**Construction Activities Stormwater Management Plan (SWMP)  
Grading, Erosion and Stormwater Quality Control Plan  
Lorson Ranch  
Fontaine Boulevard Bridge and Channel Design  
El Paso County, Colorado  
38.742243°N, -104.628328°W**

Kiowa Project No. 16031

December 21, 2017

LORSON RANCH
FONTAINE BOULEVARD BRIDGE AND CHANNEL DESIGN
GRADING PLAN & EROSION CONTROL PLAN
EL PASO COUNTY, COLORADO

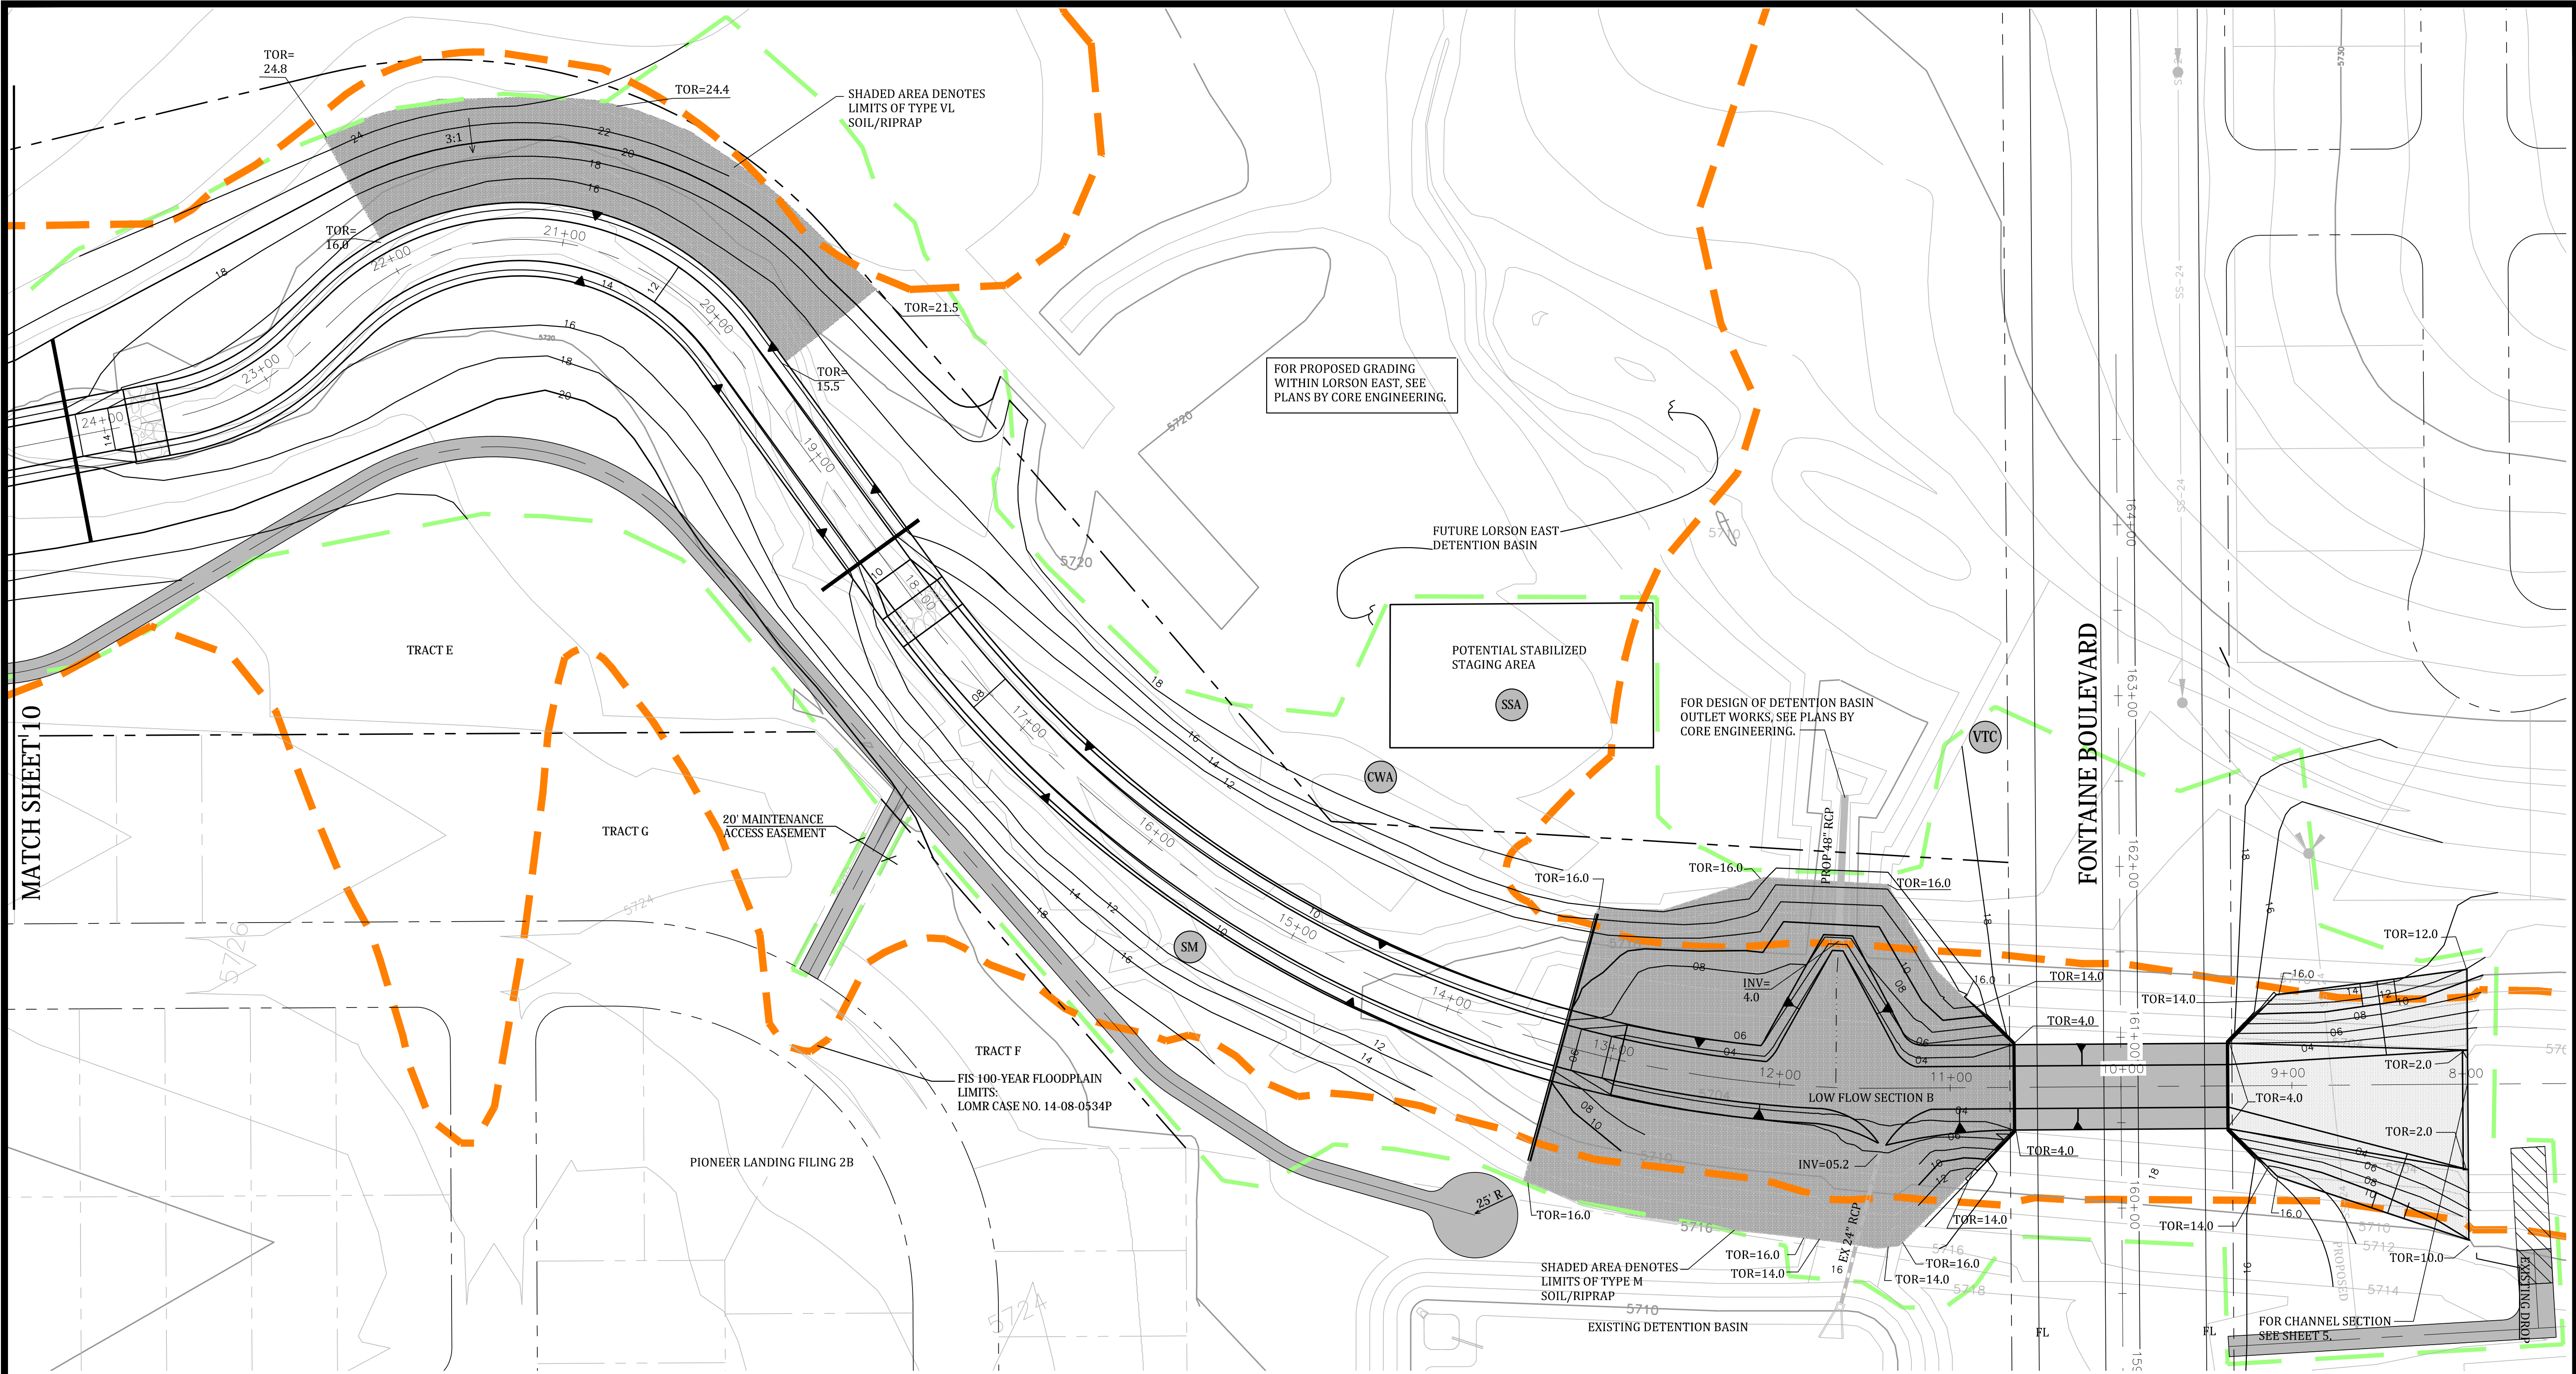
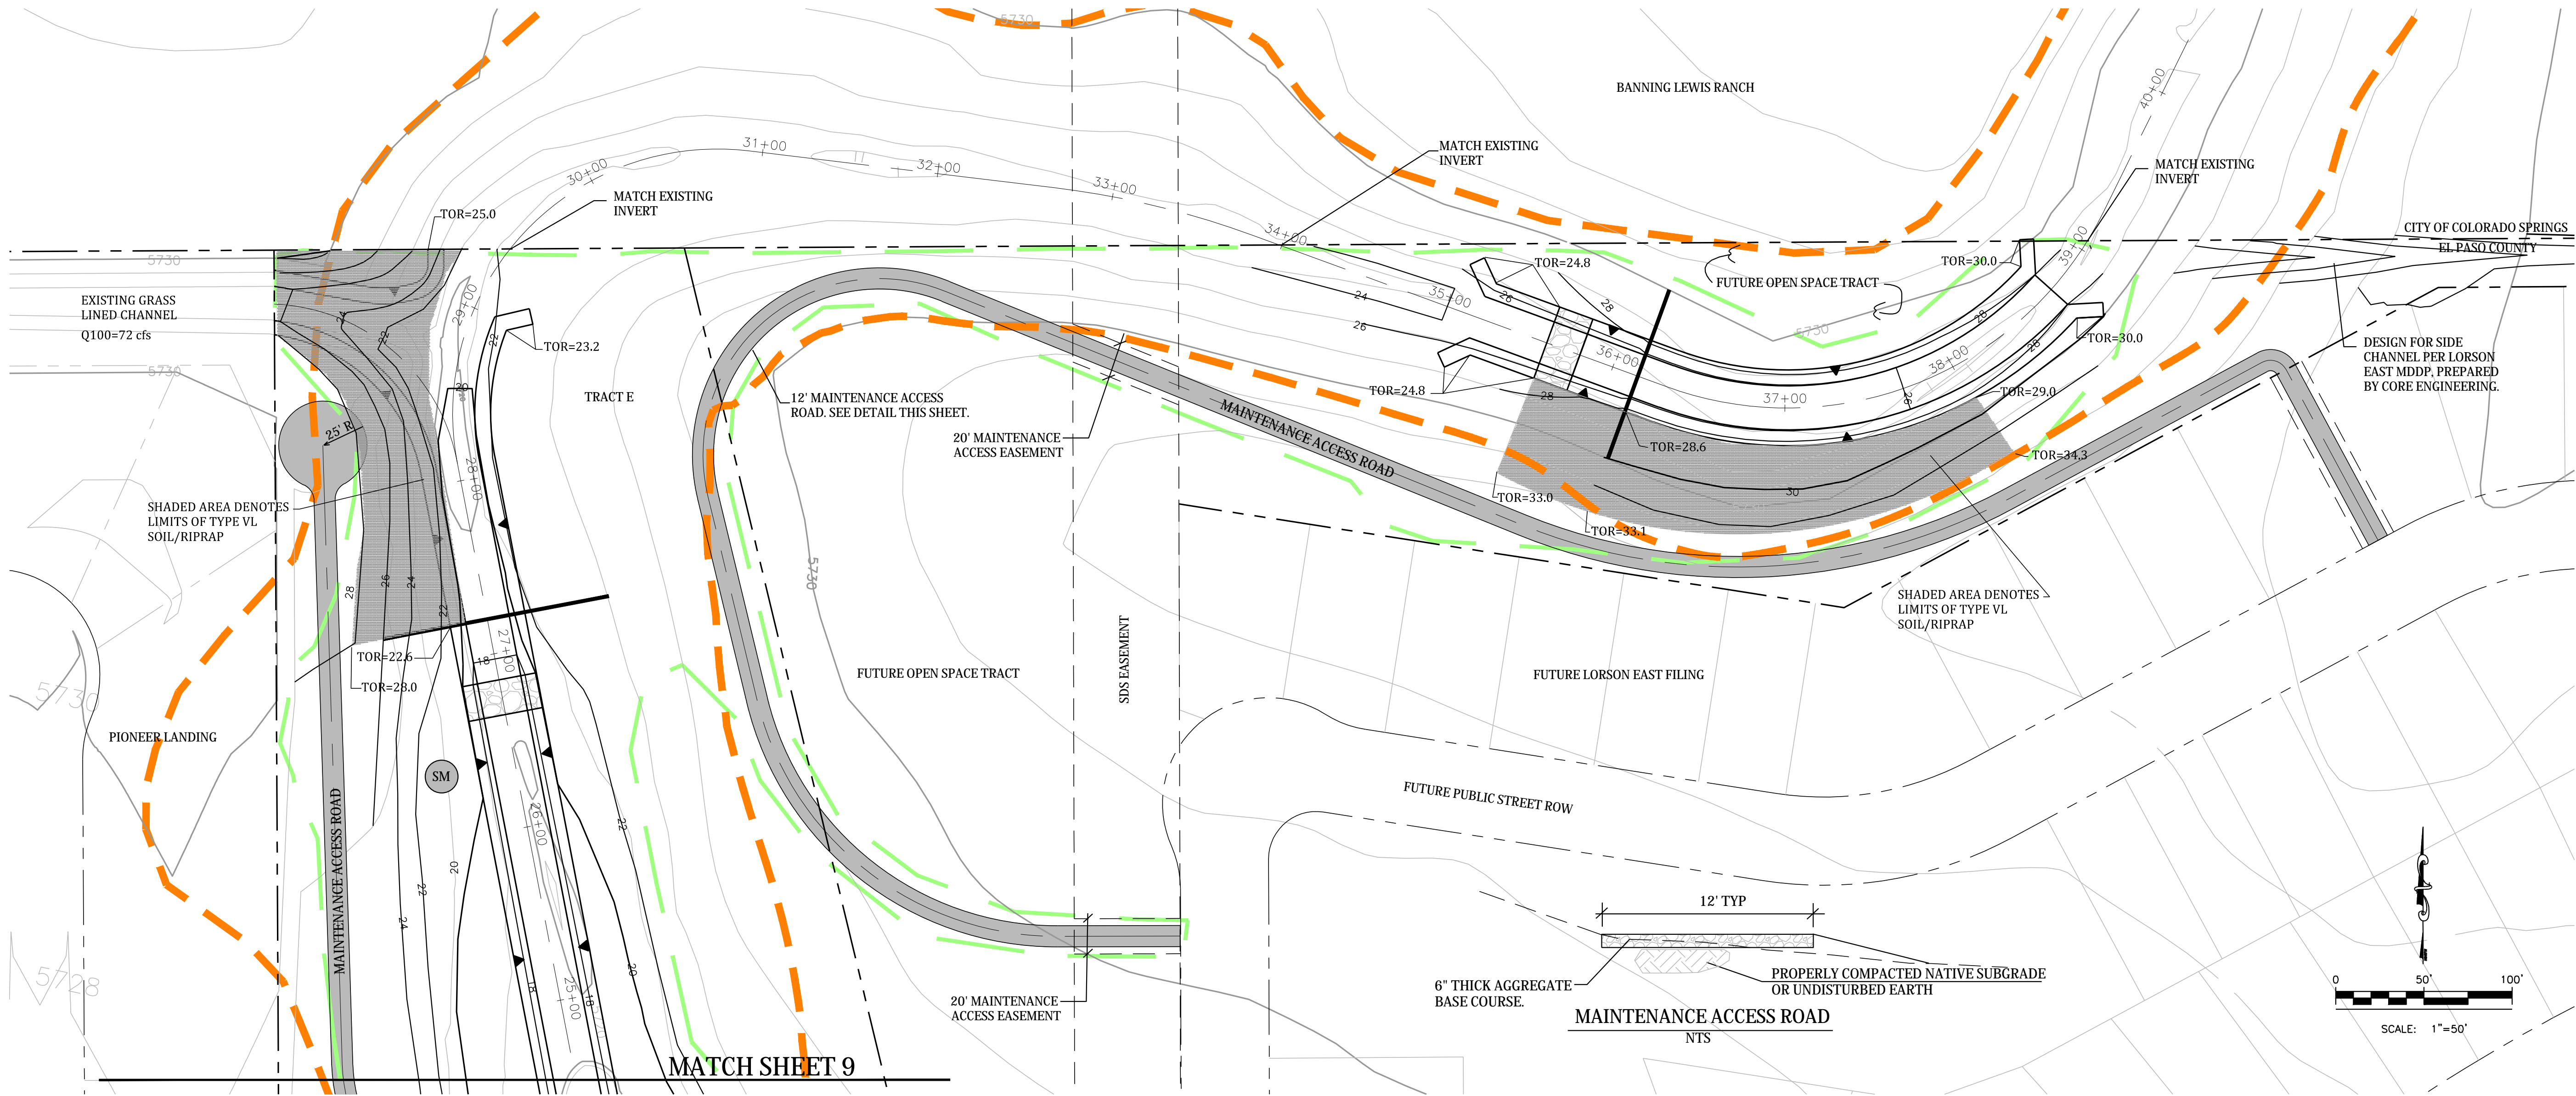
Can't see shading on this plan.

Provide
